Landscape Briefing Note 5

Project: 1080 East Anglia One North and East Anglia Two
Date: 10th January 2021
Purpose: Notes responding to SPR's Deadline 3 submissions
Reference: 1080 BN05 Deadline 3 Responses Final R1.docx

m

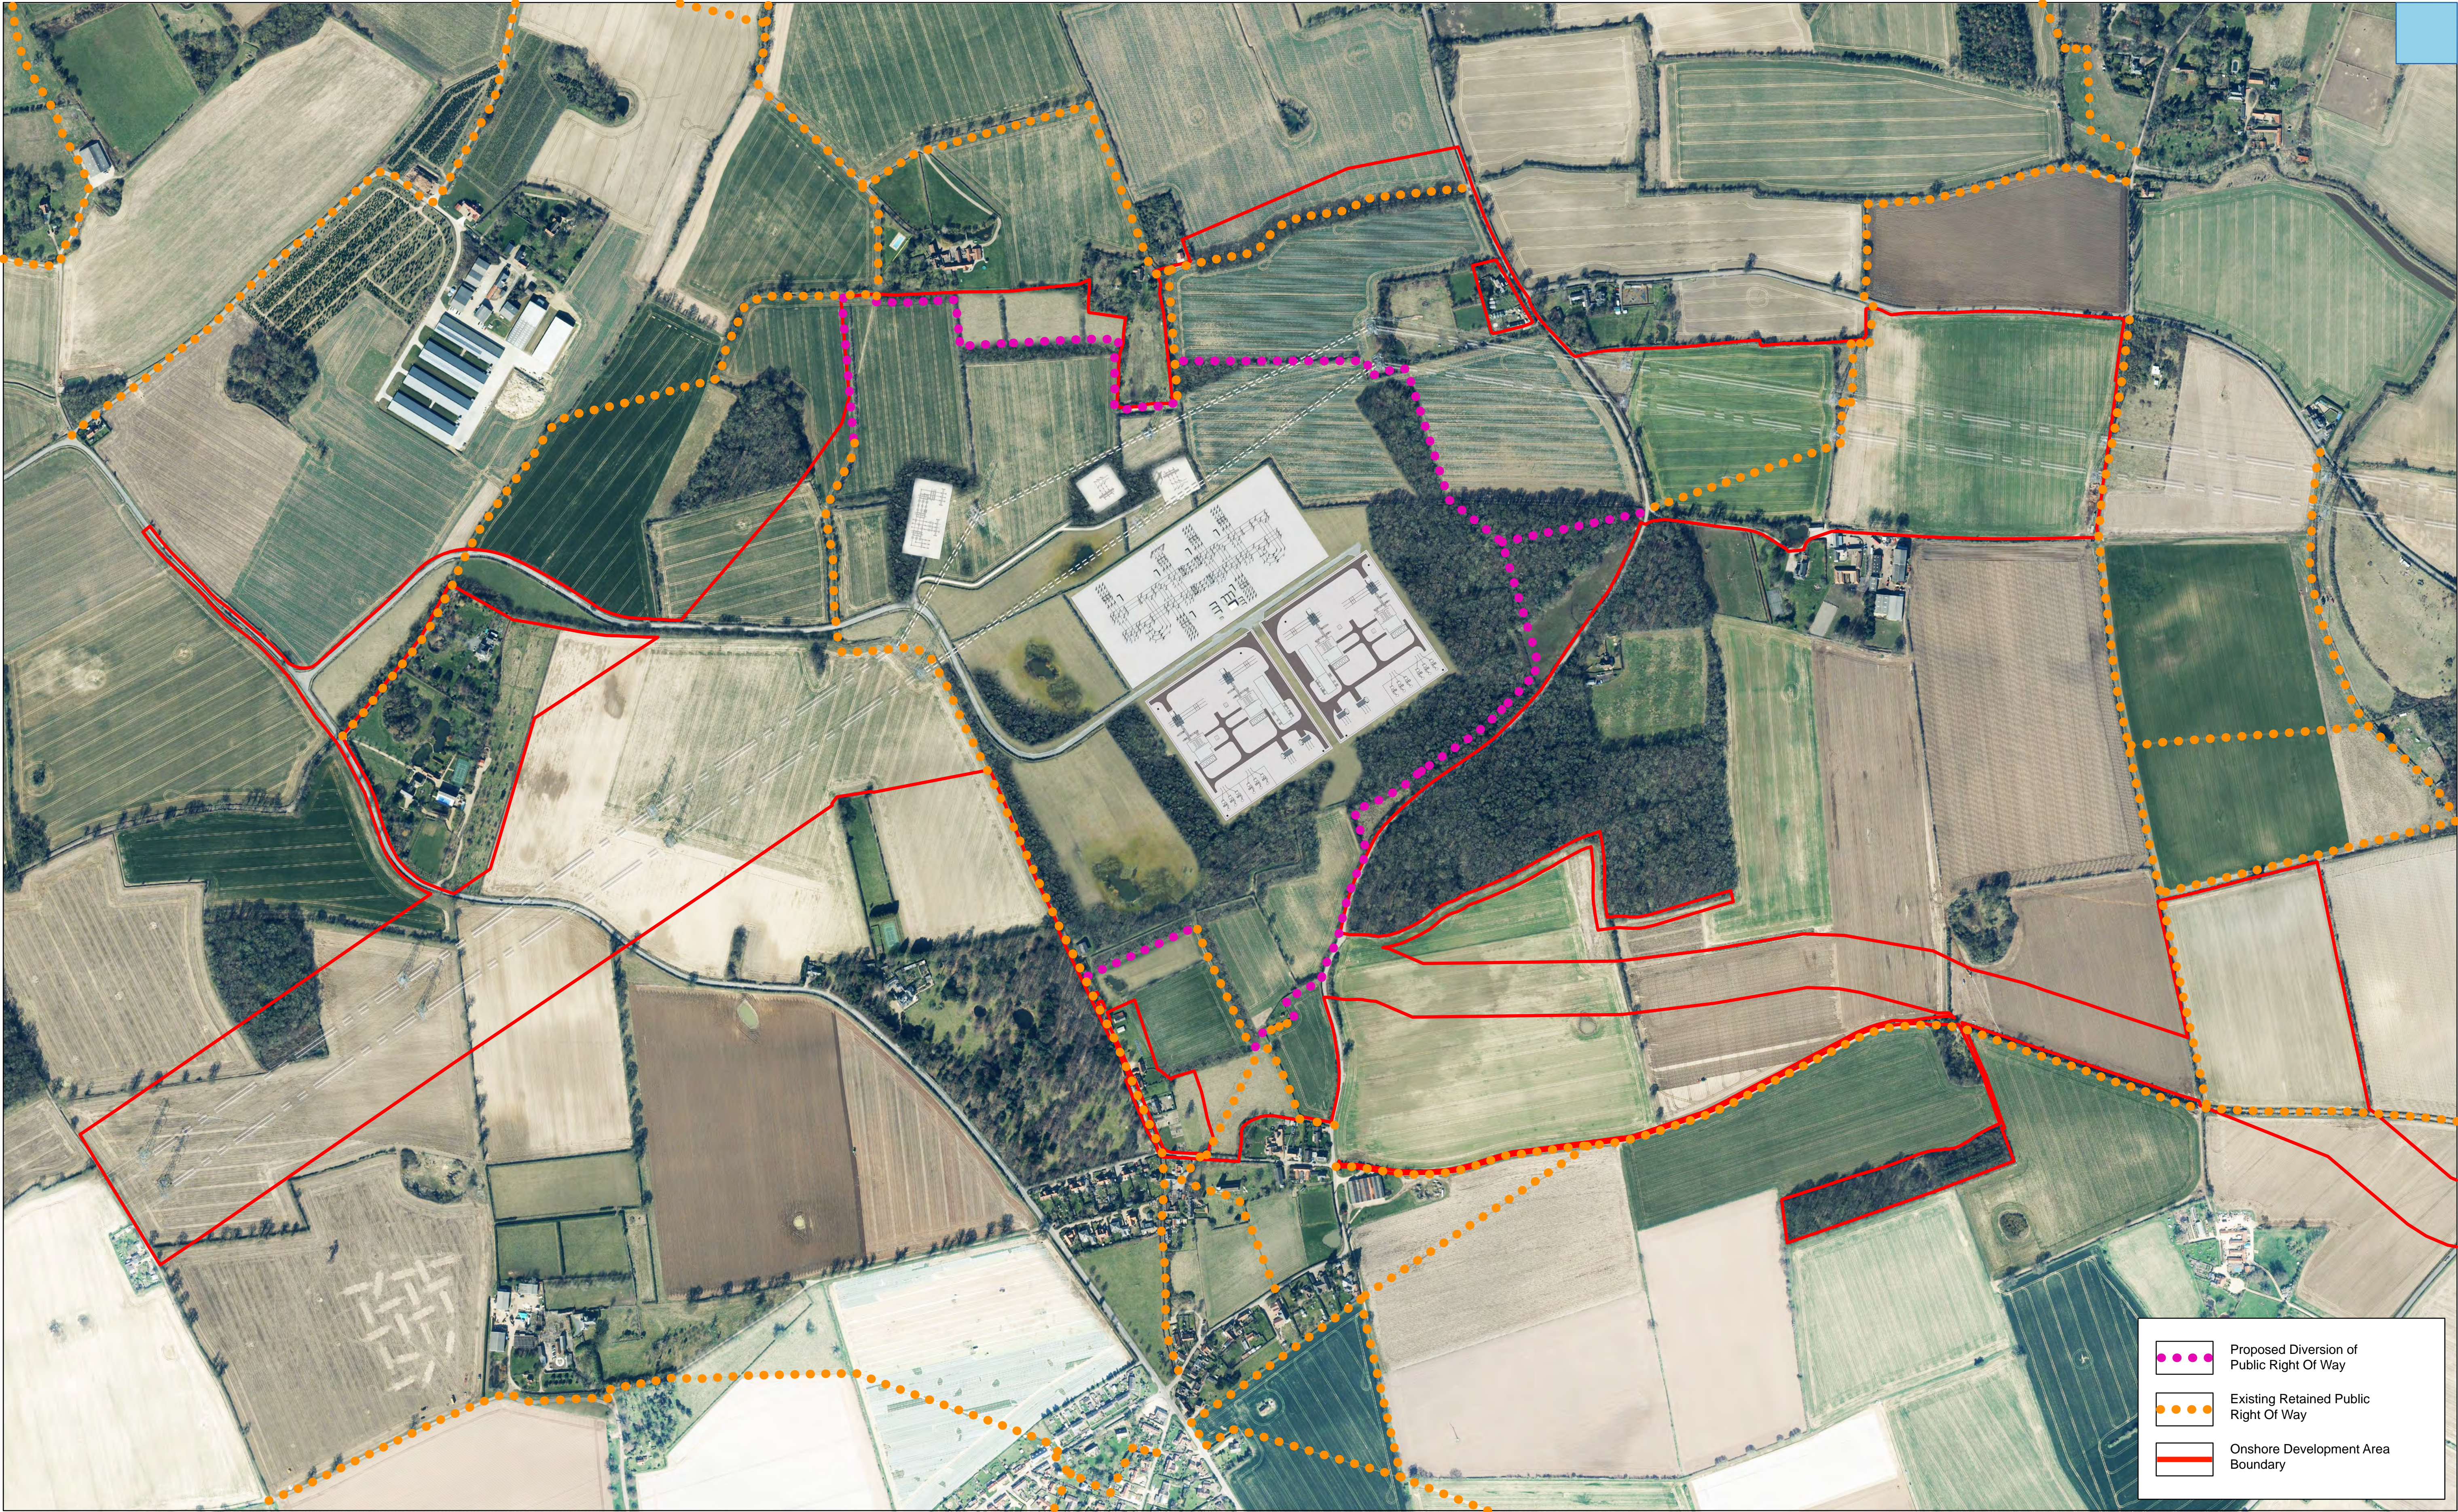
-
4. Page 15 of EN010077-003309-ExA.AS-11.D3.V1 EA1N&EA2 Onshore Substations Update Clarification Note includes Plate 5.2: *3D model of the updated easternmost onshore substation showing reduced footprint and building / equipment parameters*. A model showing both substations would be useful because previously it had been indicated (in the submitted OLMP General Arrangement drawing, Figure 3) that the substations would be ‘mirrored’ rather than repeated.

5. Plate 5.2 does not provide any indication of the orientation of the eastern SPR substation. It is only possible to understand the orientation by reference to the revised OLMP General Arrangement drawing, Figure 3¹. This shows the Super Grid Transformers and associated equipment located along the north west facing edge of the substation. Assuming this represents the orientation of the eastern substation, Plate 5.2 would be more easily understood if it was rotated 90° clockwise so that the top corner of the model represented the northernmost point of the eastern substation. It has also been inferred from the OLMP General Arrangement drawing that the western SPR substation continues to be a mirror of the eastern substation.

6. On this understanding I assume ‘access road’ means the access point into the substation. There are two external access roads to the eastern SPR substation, one along the north west facing edge and one along the south west facing edge (the edge facing the western SPR substation). The access point is from the latter. It is not clear why the external access road along the north western edge of the eastern SPR substation is required at all.

28. The SPR substations in Figure 9 OLMP Illustrative Plan (GIS) appear to be larger than in the other plans and the planting around the Cable End Sealing Compounds is omitted. It is assumed that these are drafting errors.
